FAO: Planning Department,
Welwyn Hatfield Borough Council

Ref: 6/2021/1788/FULL
Date: 16/11/2021

HISTORIC BUILDINGS AND CONSERVATION ADVICE

RE: *Campus West, The Campus, Welwyn Garden City, AL8 6BX*

ELEVATION A

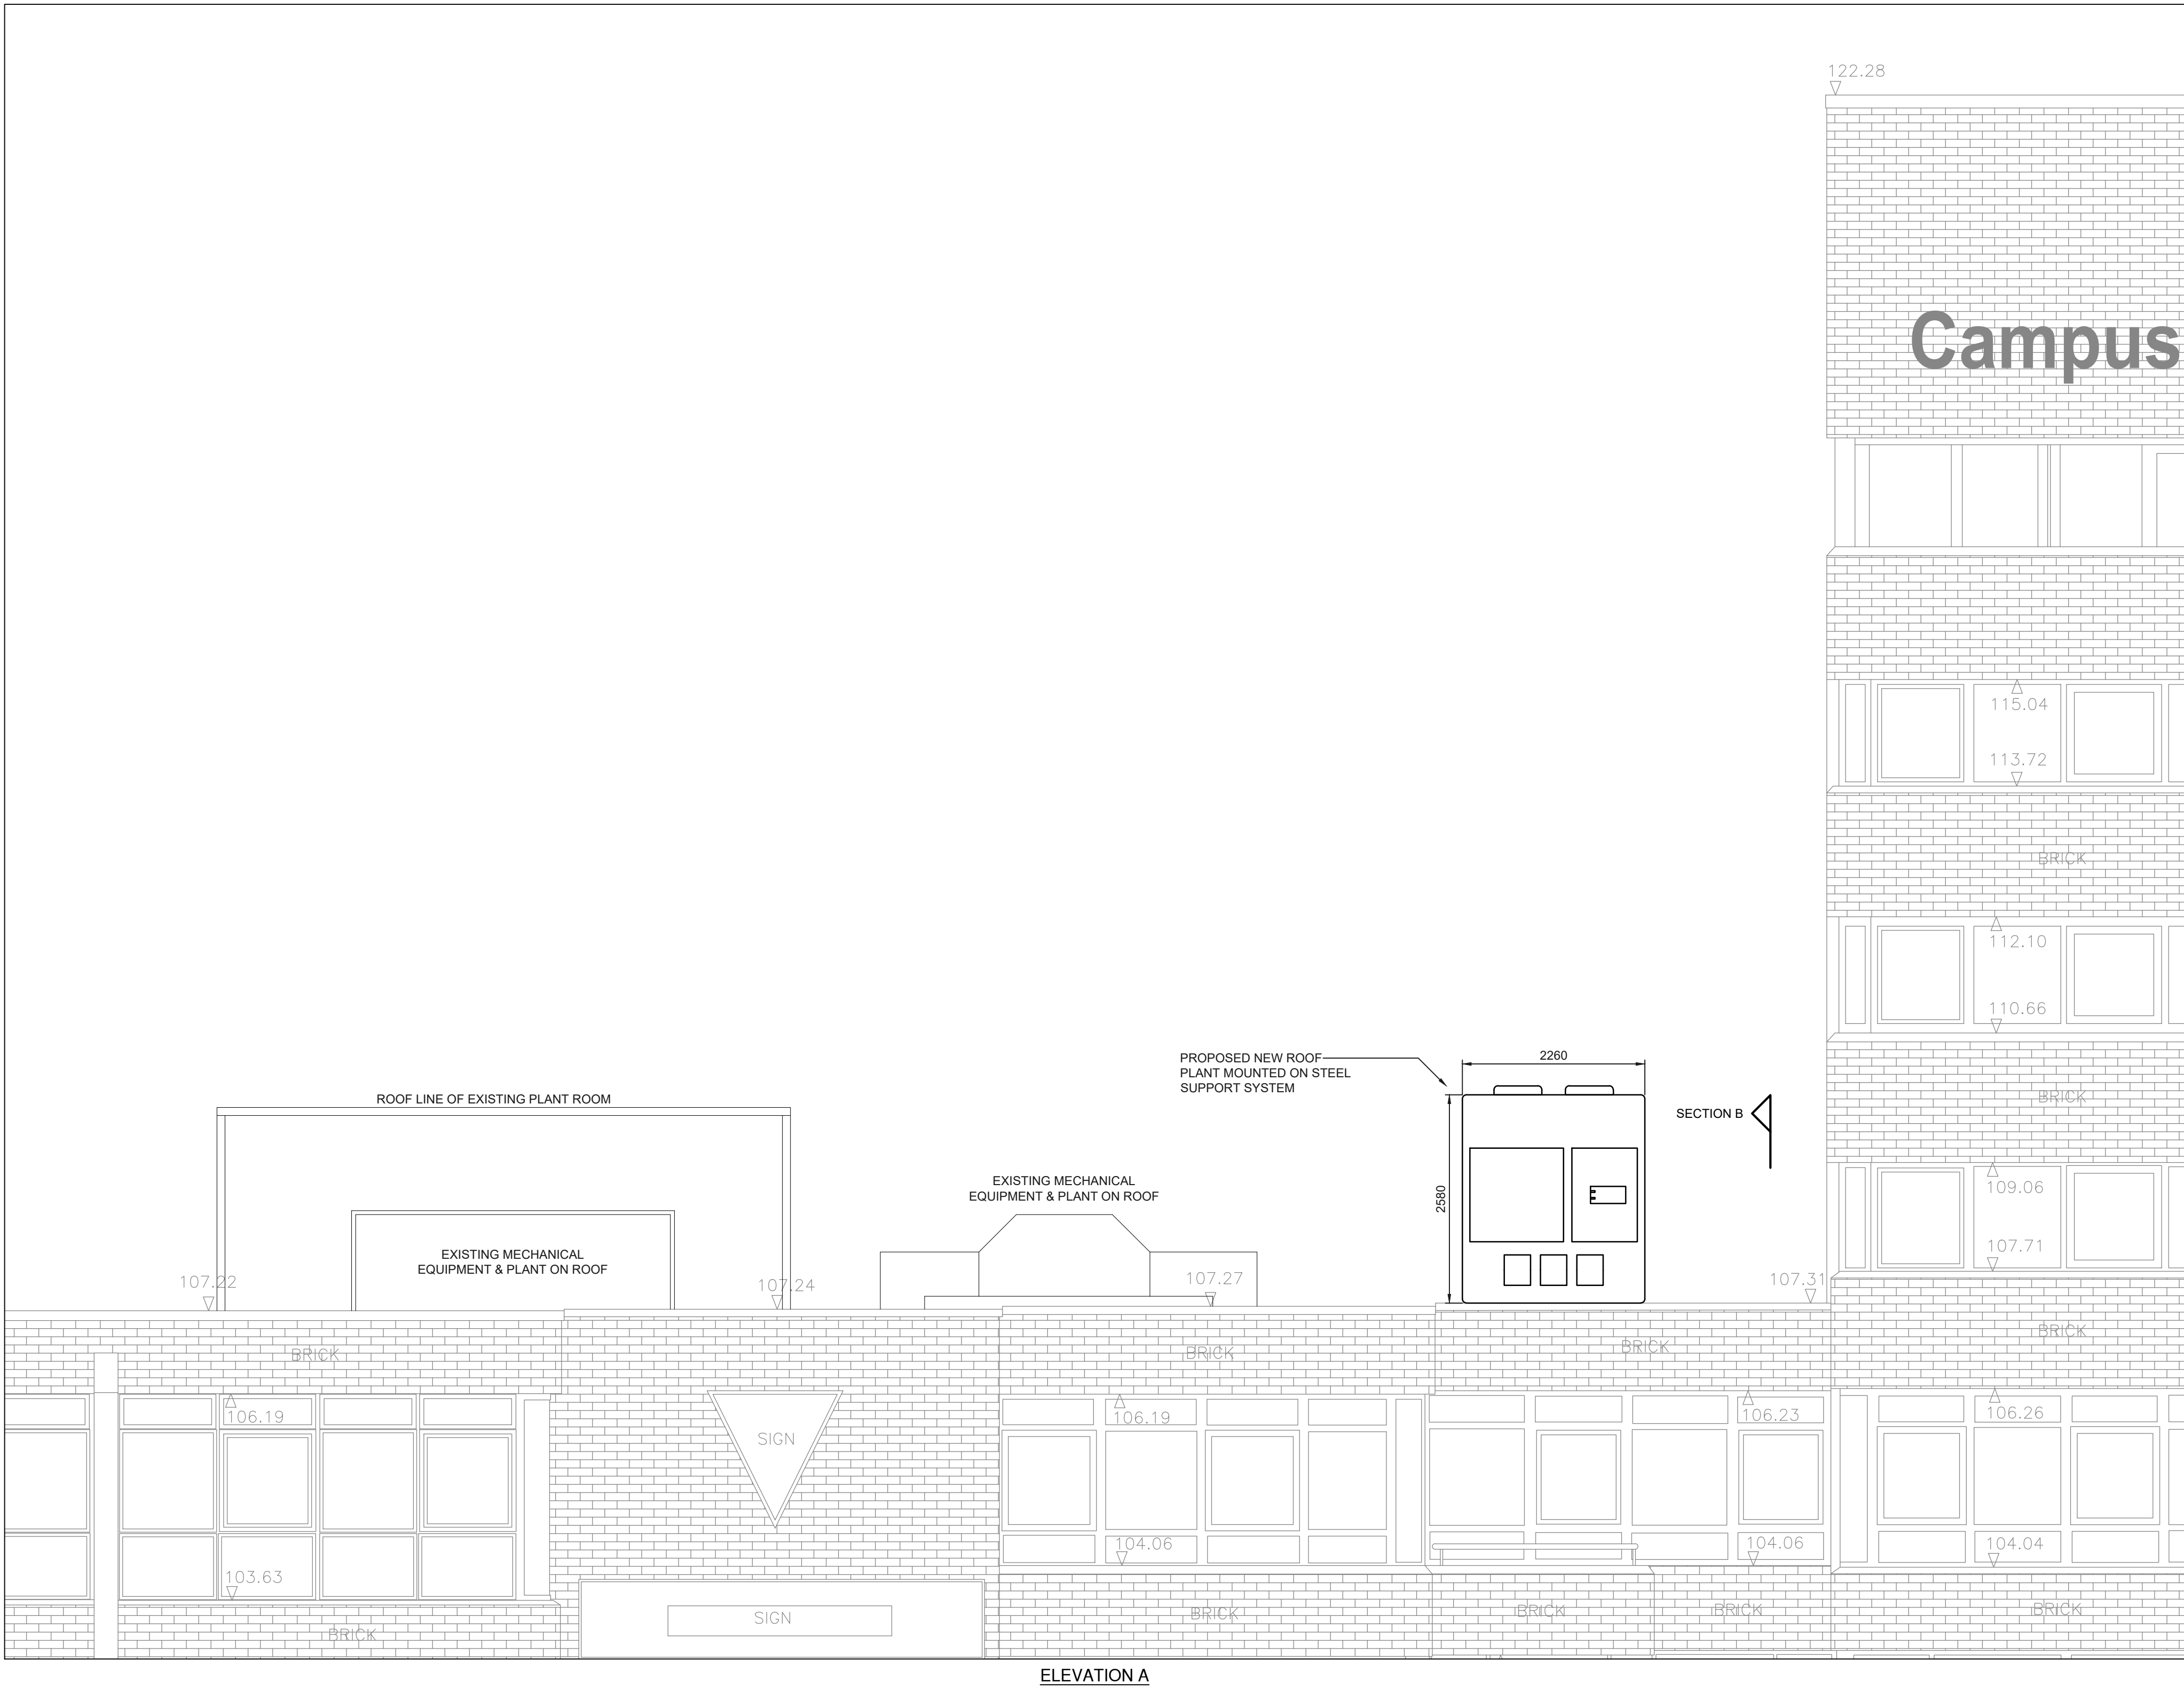
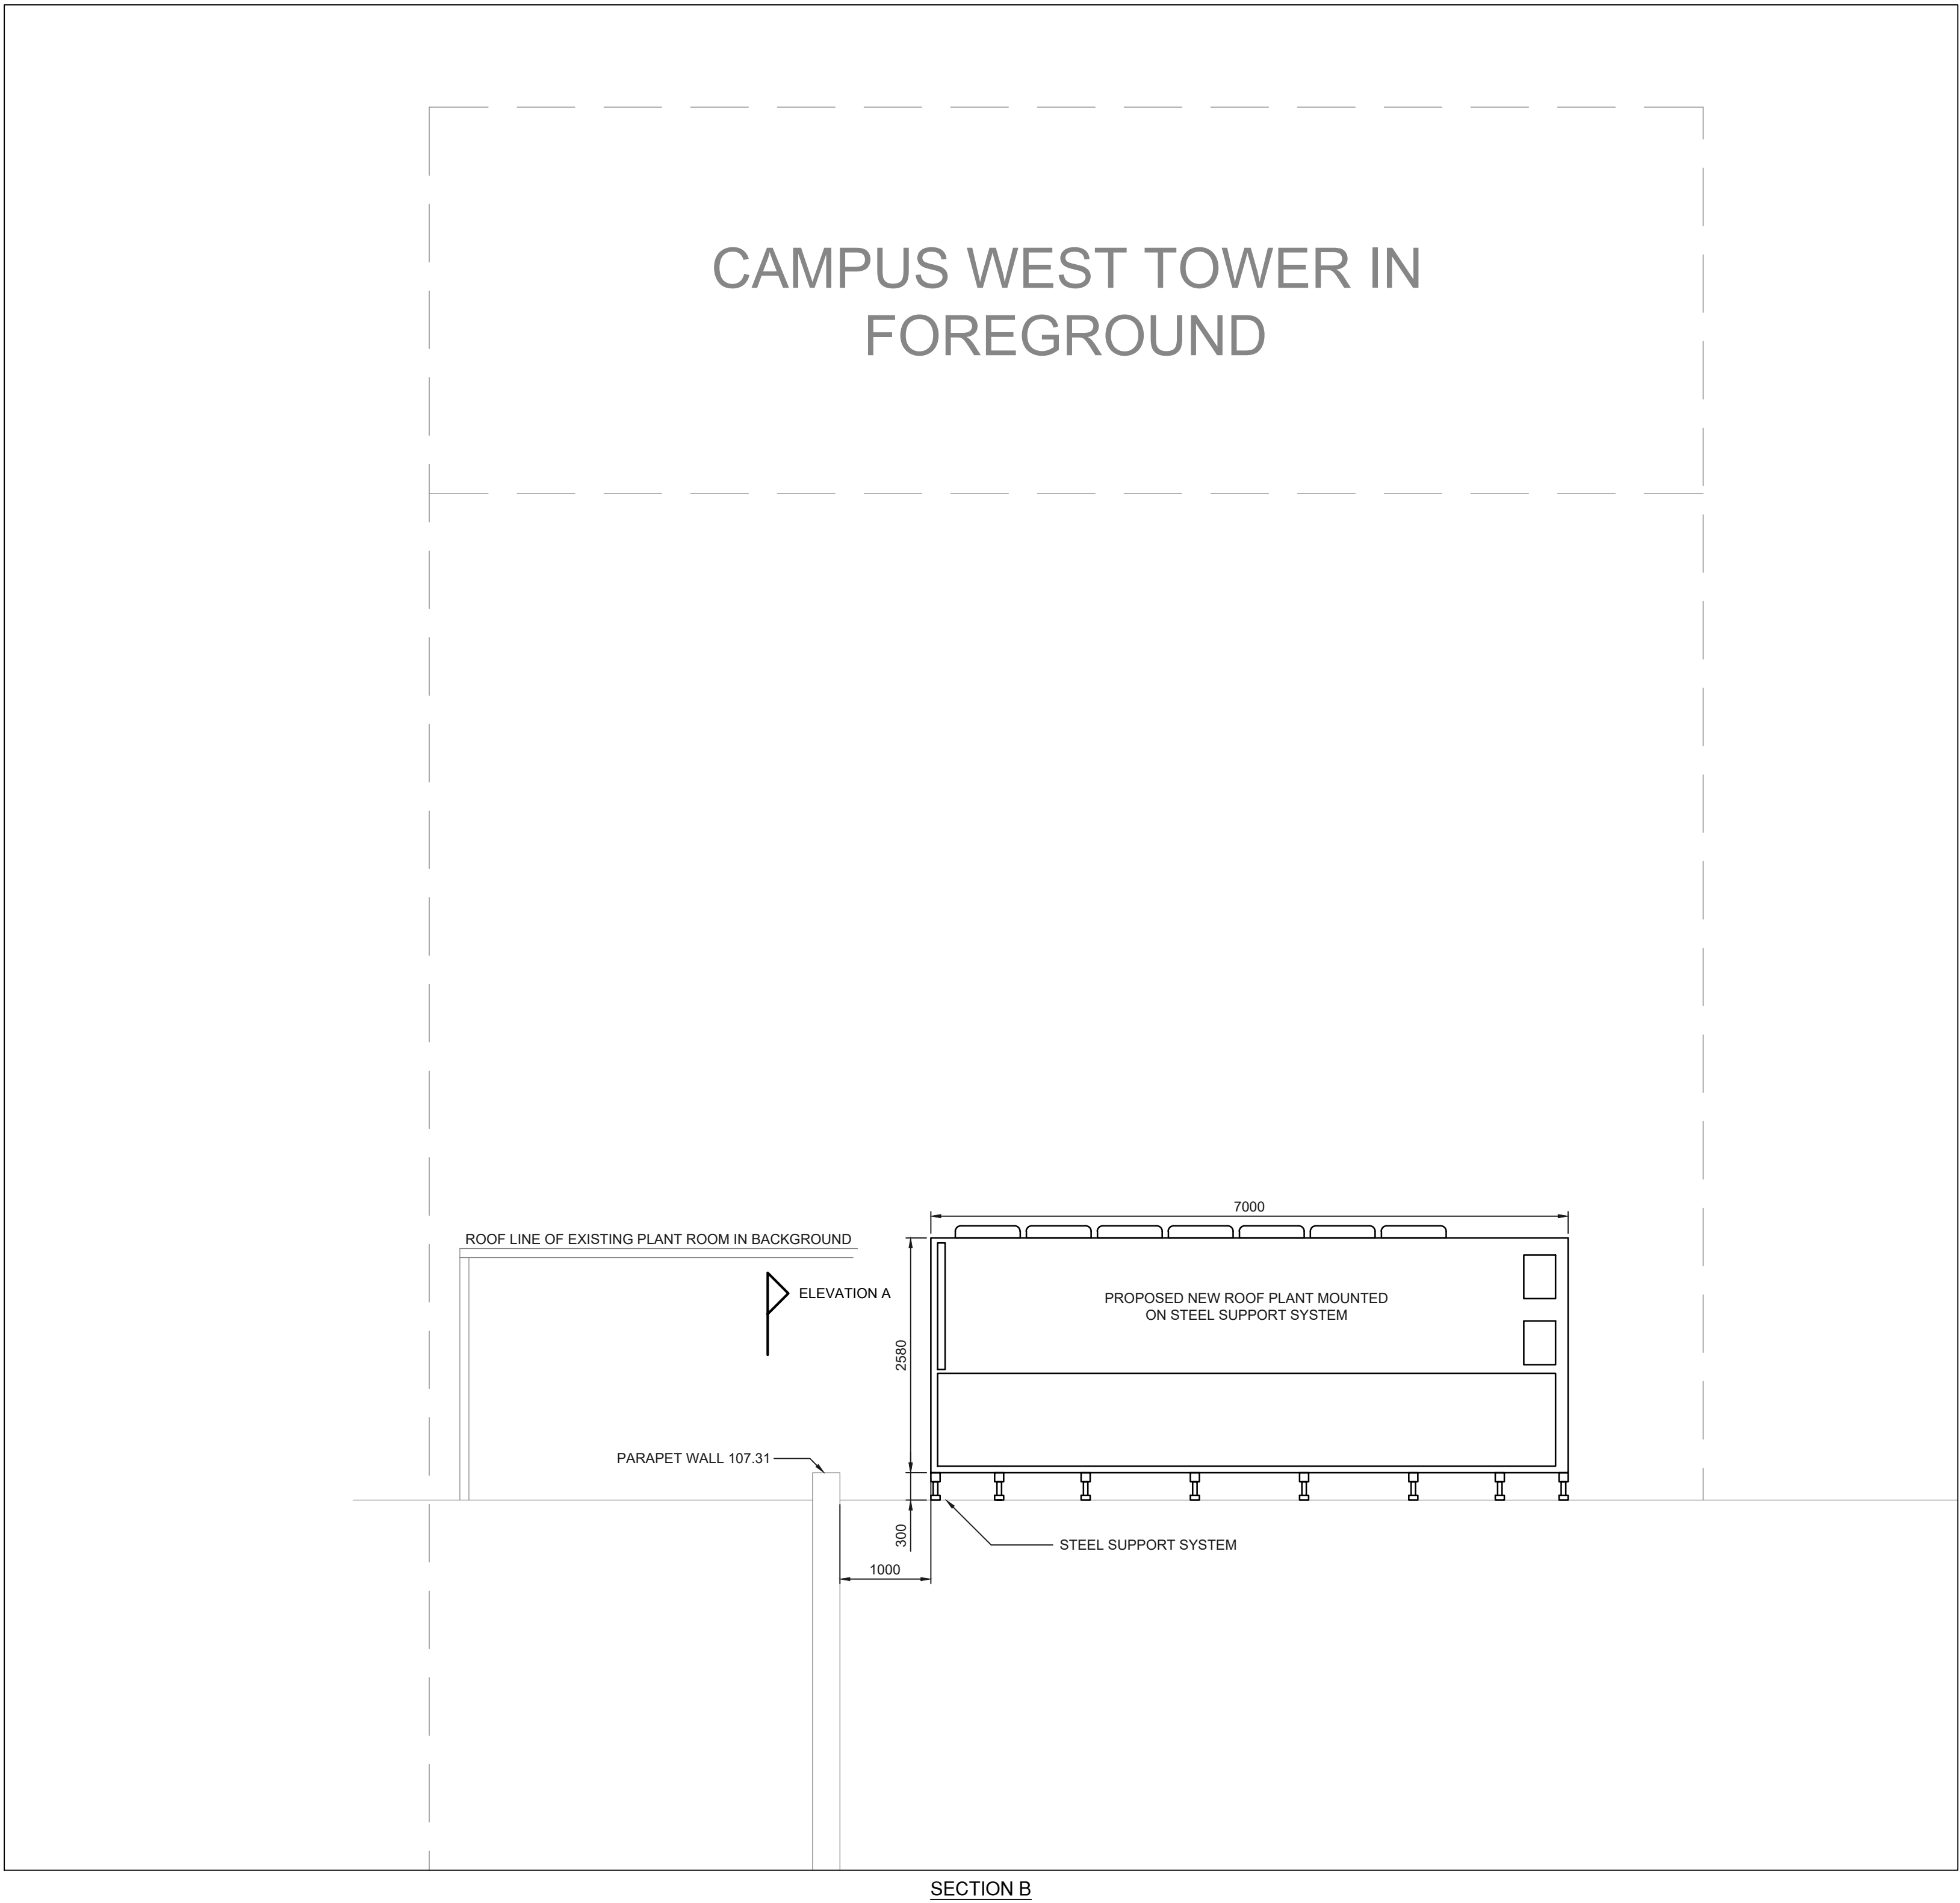
The proposed roof plant structure is a large structure at approximately 2.5 metres in height and 7 metres in length. The elevation and section drawings illustrate the position of the plant structure on the roof, and section C-C demonstrates that it is set relatively far back on the roof from the elevation (A) fronting The Campus.

Long views of Campus West from locations across The Campus are possible, but many are filtered by trees when they are in leaf. The proposed plant structure will be located alongside existing plant on the roof which is perceivable in some views, but not prominent. Whilst the proposed plant structure is much larger than the existing structures on this part of the roof, it is not considered that it will appear as a prominent feature in views of Campus West from The Campus and will not detract from its overall appearance due to its set back position.
